Les Schwab Tire Center Storm Report

**EPC STORMWATER REVIEW COMMENTS
IN ORANGE BOXES WITH BLACK TEXT**

**7105 Old Meridian RD.
Falcon Colorado**

PCD Filling No.:
PPR-21-023

D.1

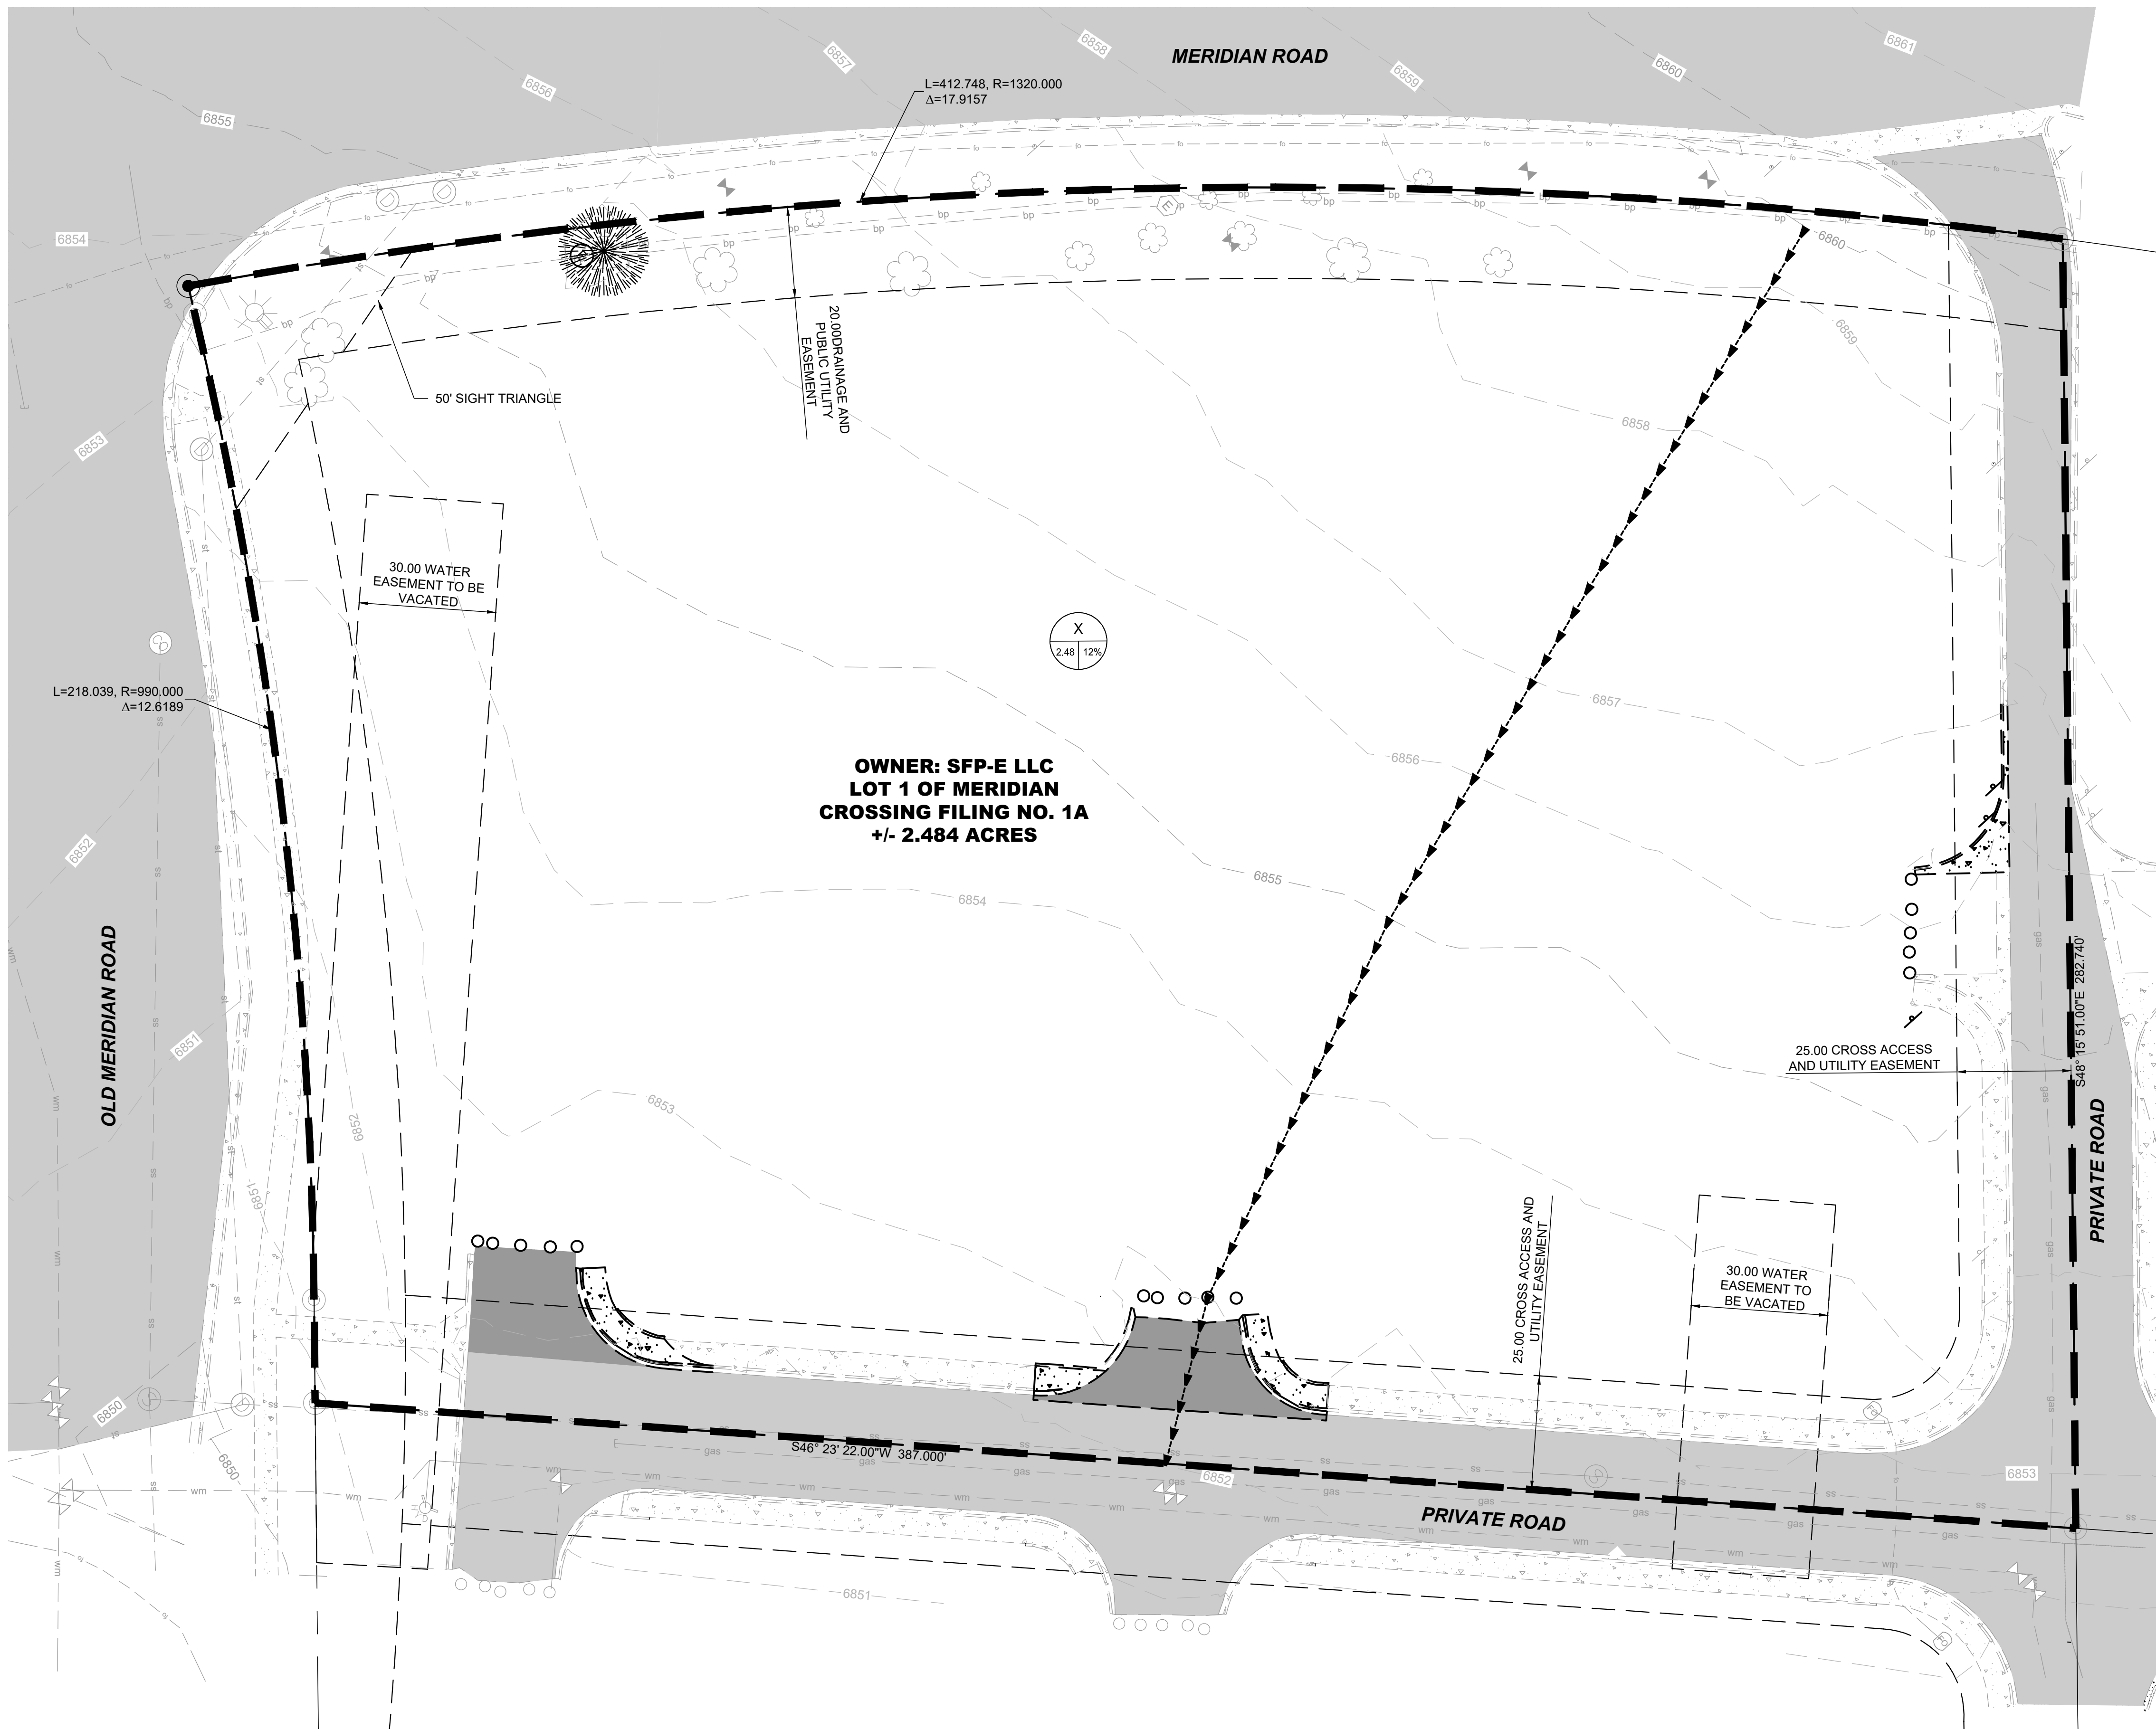
Add a legend to define linestyles in both existing and proposed drainage maps.
